Our ref: DOC21/261582

**RE: Review of GCOP Response to Heritage NSW Advice Relating to the Response to Submissions Report for the Glendell Continued Operations Project (SSD-9349) – Specifically Recommendation 2 (DOC20/695489)**

Thank you for your referral dated 6 April 2021 requesting Heritage NSW (HNSW) review the correspondence from Glencore to the Department of Planning, Industry and Environment (DPIE), dated 1 April 2021 in relation to the proposed State Significant Development (SSD) for the Glencore Continued Operations Project (GCOP) SSD-9349.

FIGURE 1

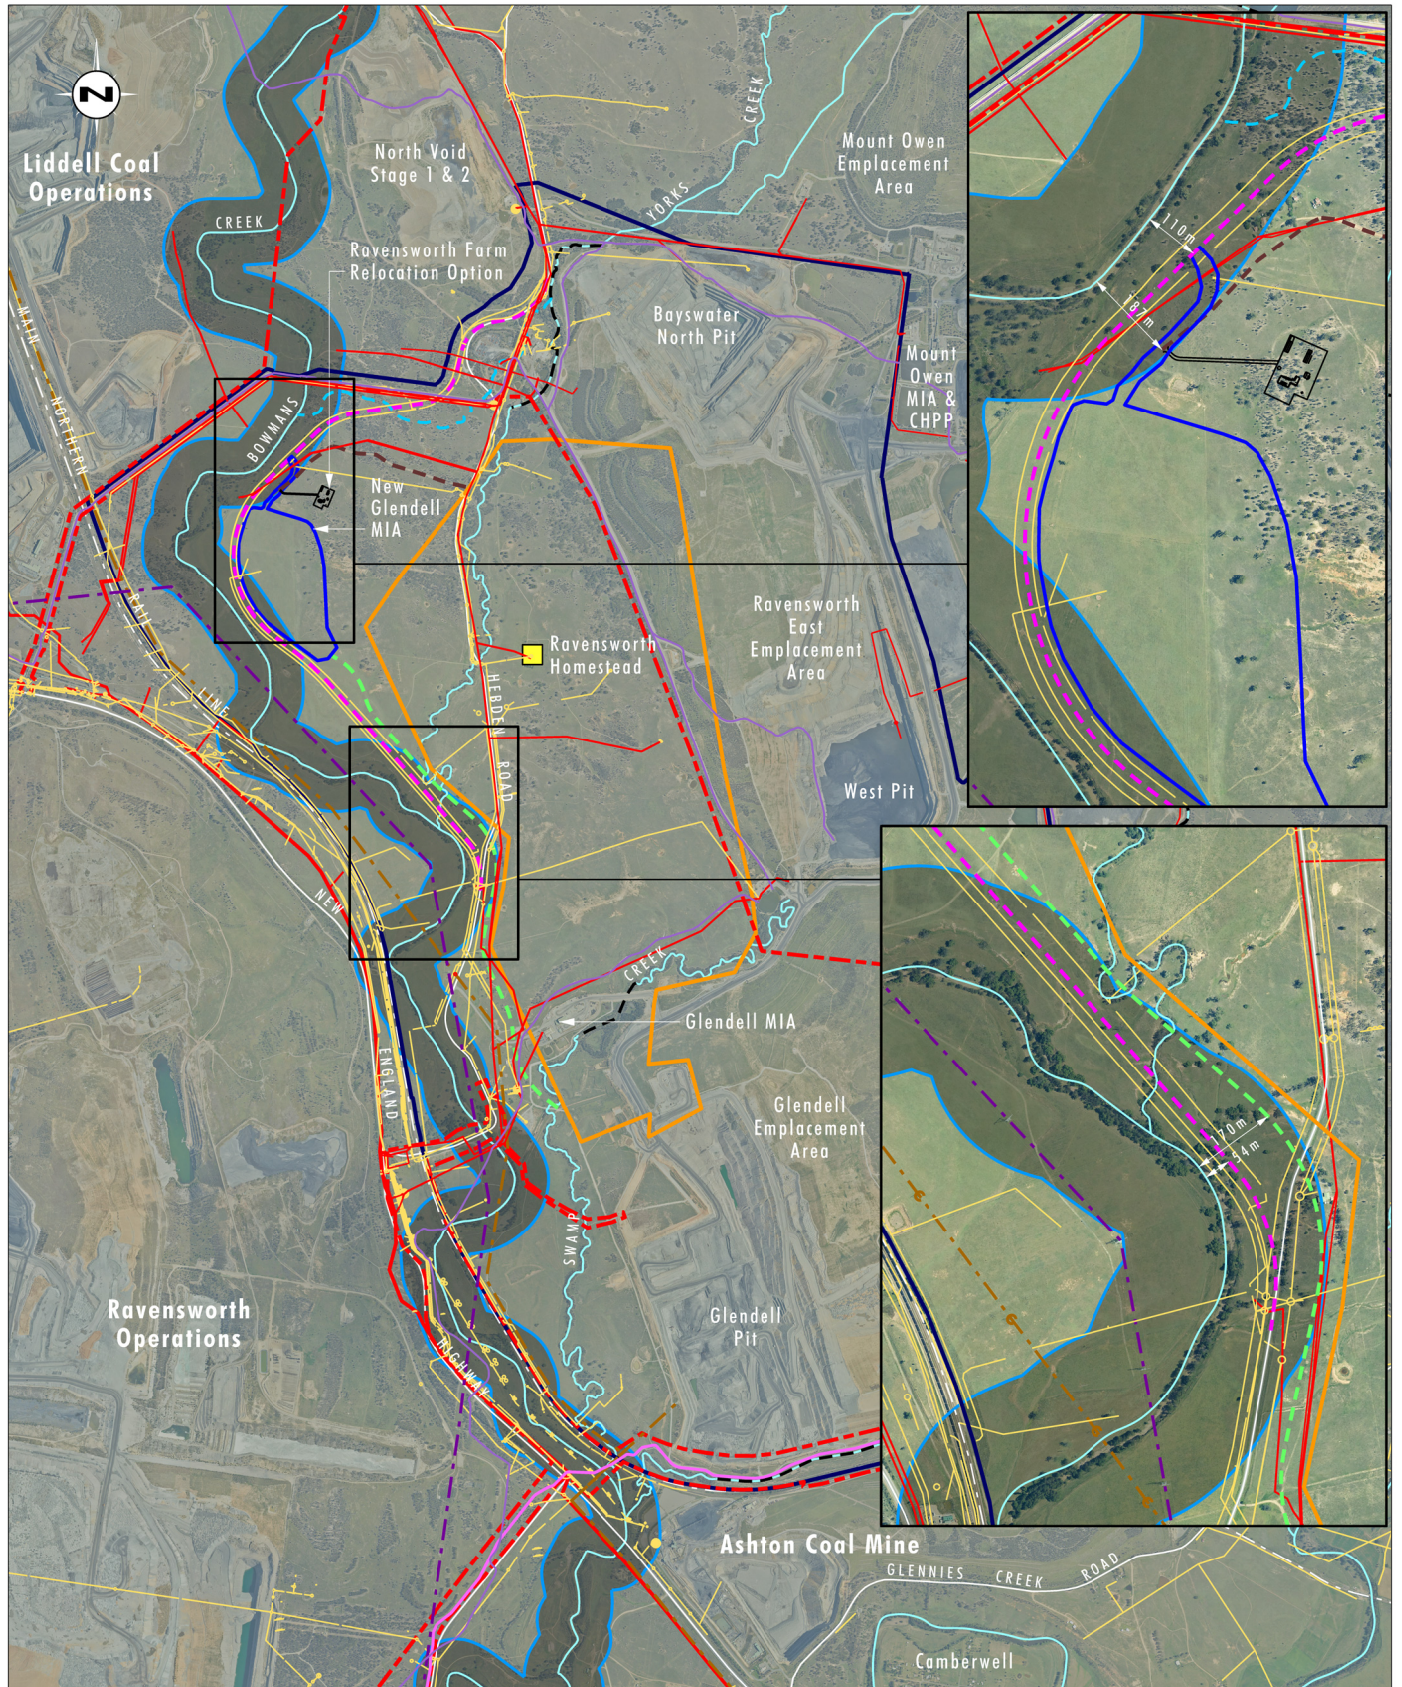
HNSW has reviewed the correspondence from Glencore dated 1 April 2021. Glencore have provided information noting that works relating to the Hebden Road realignment, heavy vehicle access road, lower reaches of the proposed Yorks Creek realignment, Mine Infrastructure Area (MIA) and rehabilitation works are partially situated within 200 metres of Bowmans Creek.

GCOP state that the proposed infrastructure works are critical to the effective operation of the Project and that the location and alignments have been optimised to minimise impacts. They refer to Section 7.4.2.5 Bowmans Creek of the *Glendell Continued Operations Project Environmental Impact Statement* EIS prepared by Umwelt and dated 29 November 2019, which ensures that the proposed mining extraction area (Glendell Pit Extension) is offset at least 200 metres from the top of the high bank of Bowmans Creek to minimise potential impacts on Bowmans Creek.

Glencore requests that Recommendation 2 be removed to be consistent with the project design objective of having no mining within 200 metres of Bowmans Creek.

Following consideration of the above information, HNSW agree that Response to Submissions Recommendation 2 can be removed as requested.
